Consultation Response from KC, Lead Local Flood Authority
2021/93689 Land to the south of, Ravensthorpe Road / Lees Hall Road, Dewsbury
Hybrid application for full planning permission for engineering works, drainage and utilities connection for the provision of site access from Forge Lane and Ravensthorpe Road and associated works; and for outline permission for erection of residential development and mixed use development (including community facilities) with associated works including the provision of internal estate roads and parking, landscape works (including provision of public open space, tree clearance/replacement/woodland management and ecological management) and sustainable urban drainage works drainage principles
Date Responded: 19th December 2022 Responding Officer: Paul Farndale Responding Ref:

Kirklees Flood Management and Drainage acting as Lead Local Flood Authority continues to OBEJCT to this application.

Figure 1-4 Existing Offsite Drainage

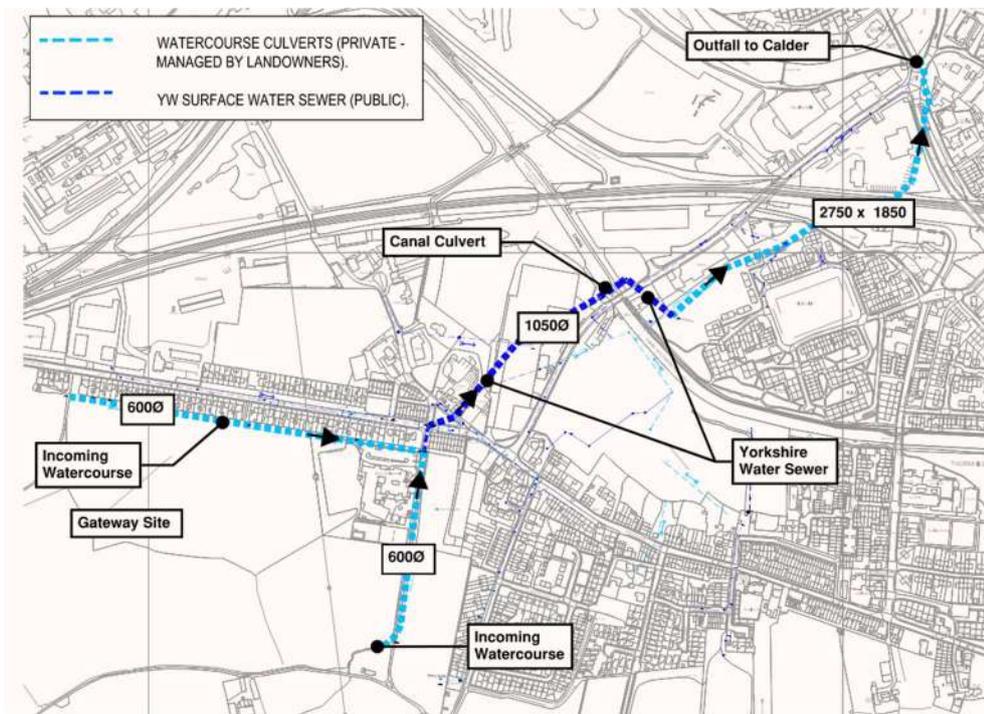
A local 600mm private drain will need some attenuation and reconfiguration to protect existing properties from any potential run off from the site during construction and after.
